Application Reference: 2025/0295

Site Address: 109 Greenside, Staincross, Barnsley, S75 6AX

Introduction: This application seeks full planning permission for the erection of a wrap around side and rear extension.

PROPOSED SOUTH ELEVATION

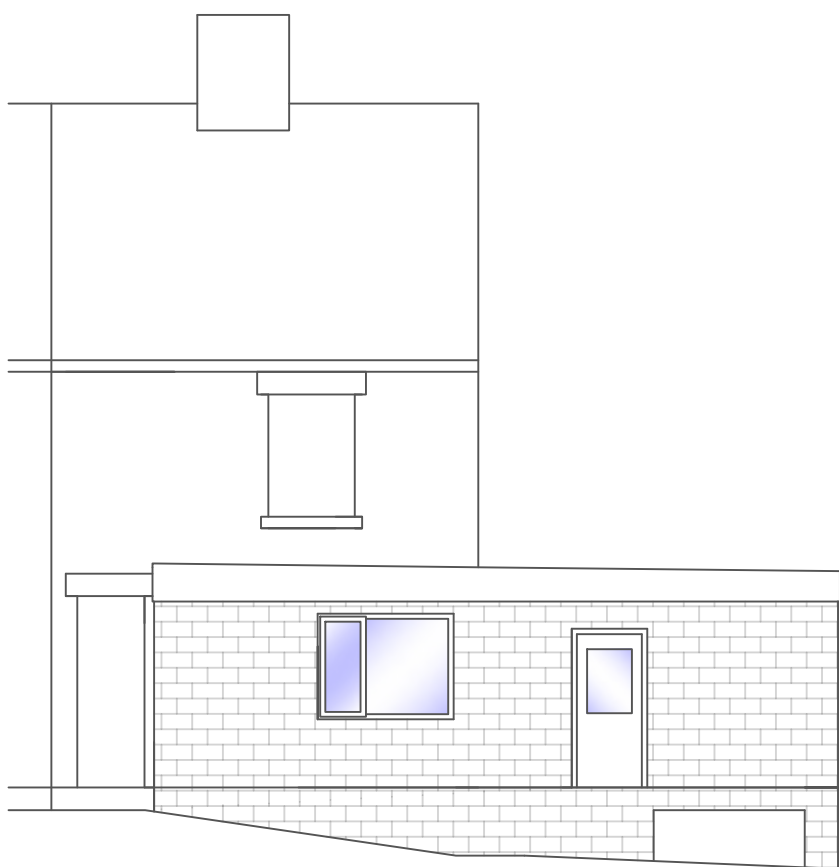
Due to the significant ground level difference between the front and rear elevations of the dwelling, and the side garden, the height of the proposed extension would be much higher than a standard ground floor extension. This is due to the requirement for supporting columns, which would support the proposed extension's approximate side projection of 4.72m and width of 13.8m. As a flat roof is proposed, this would minimise the overall height of the proposal, with the roof height being approximately 4.86m from ground level or 2.91m from the ground floor level of the house. However, the consequential impact of a flat roof, in addition to its height, would it not be in keeping with the design or character of the dwelling, in accordance with paragraph 5.10 of the SPD House Extensions and Other Domestic Alterations (SPD House Extensions), which was adopted in 2019, it is stated that the 'roof, style pitch and detailing should match those of the existing dwelling'

In broader terms of design, beyond what has been raised in concern to the scale and subsequent impact to the dwelling, the proposed materials and more intricate design features of the proposal have varying impact. The proposed reconstituted stone, used within the extension would be complementary to the original dwelling. In contrast the proposed windows and glazed doors would be of differing design and proportions to the original dwelling, whilst also not featuring stone cills or lintels. Although the proposed windows are not located on a principal elevation, they still remain publicly visible and would remain of considerable concern. Paragraph 5.19 of The SPD House Extensions states

Therefore, with other more significant design principles not met, such as the flat roof, the design and subsequent impact on the design and character of the dwelling would be considered as moderate.

As a result of limited direct overlooking from the proposed windows, the issue of the raised decking area arises. Whilst alike to the proposed extension, the decking would not directly overlook the rear gardens or windows of dwellings to the south of the dwelling. Because of the use of the decking, by current or future occupants of the dwelling, especially at such a height disparity to neighbouring dwellings, there is the possibility of both direct and indirect overlooking of gardens and first floor windows of neighbouring to the southeast, when the decked area is in use.

In accordance with paragraph 7.32 of the House Extensions SPD, on this occasion if amended plans had been put forward to be considered, a request would have been made to incorporate some screening at the south and southern corner of the decking, in order to preserve the neighbouring amenity of dwellings to the southeast of the dwelling. Such measures would not be expected themselves to cause any further detriment to neighbouring amenity.

As assessment can only be made on the supplied plans, in the current form, the proposals would be considered to have a significant impact on neighbouring amenity. Therefore, the proposal would be deemed not to be fully compliant with Local Policy GD1. This would carry moderate weight against approval of the application.

PROPOSED FLOOR PLAN

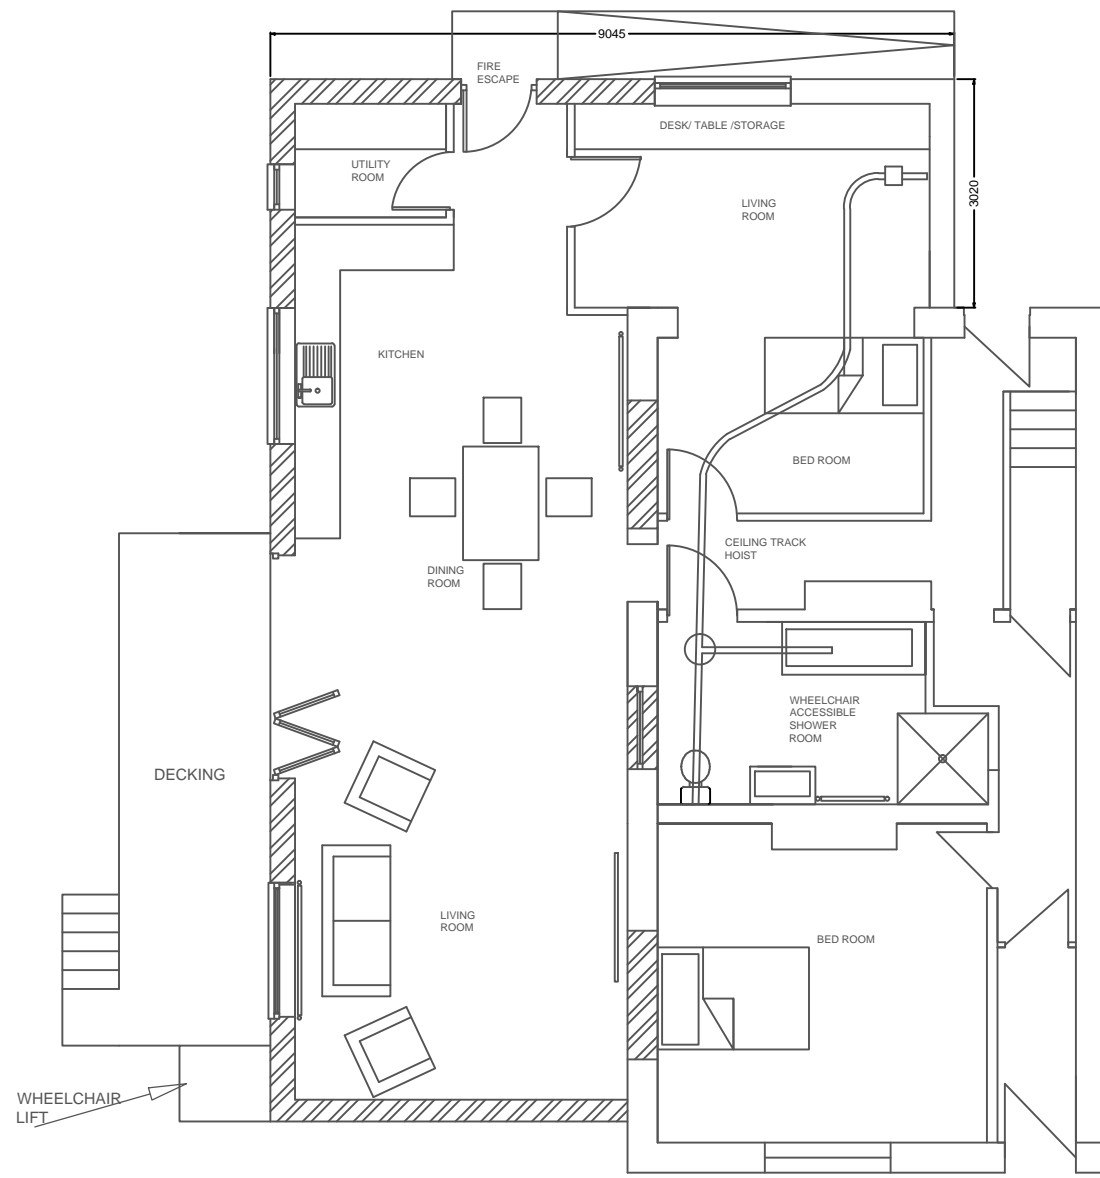
If the side aspect of the wraparound extension was considered as rear extension, the rear projection and the eaves height would both exceed the prescribed allowances of the SPD house extensions, with a rear projection of 4.72m instead of the 3.5m allowable for terraced houses or 4m allowed for semi-detached houses. Equally, the eaves height, whether considered from the ground level or ground floor level, at approximately 4.86m or 2.91m respectively, exceed the suggested 2.5m limit for extensions with a rear projection over 3m. Whilst there is no prescribed eaves height limitation, it is common to follow the guidance of General Permitted Development, where the eaves height should not be higher than the eaves of the original house. Whilst there is no particular concern with the eaves height, the issue of the flat roof remains, where at least a lean-to roof would have been deemed more appropriate and in accordance with SPD house Extensions guidance paragraph 7.19, as detailed below.

As noted above, paragraph 7.19 also provides guidance that the projection of a side extension should not be excessive, with an example of no more than two thirds the width of the original dwelling. If this requirement was strictly imposed, the proposed side extension would have been required to be reduced in size from 4.72m at ground floor level to 4.14m, two thirds of the original dwelling’s 6.21m width.

both the side and rear aspects of the whole extension which creates an excessive sized proposal. As such a suggestion of removal of the rear wraparound aspect of the proposal was suggested but ultimately rejected by the applicant.

On this occasion, whilst as much discretion as possible has been given to both the determination of elevations, and more significantly the scale of the proposal, on the basis of need expressed by the applicant, the current proposal would result in an excessively large extension which has a considerable impact on the original scale, design and proportions of the original dwelling, and would exceed the limitations of being a subordinate feature. Therefore, the scale of the proposal would be deemed as having a considerable impact on the scale, design and character of the original dwelling.

In addition to the proposed extension, an area of raised decking around the extension has been proposed. The decking replaces, albeit now further into the rear garden, current decking which is undoubtedly in need of repair. Whilst the proposed decking does not directly affect what may be considered as an acceptable scale for the proposed extension, it would in isolation remain of a scale and at a location which may normally be considered acceptable, in accordance paragraph 7.31 of the House Extensions SPD. However, because the decking also incorporates the provision of a disabled lift to and from house and parking provision, via the side garden, the proposed decking if reduced in line with a reduction in scale of the proposed extension would likely be considered acceptable despite potentially having a moderate impact on the scale, design and character of the original dwelling.
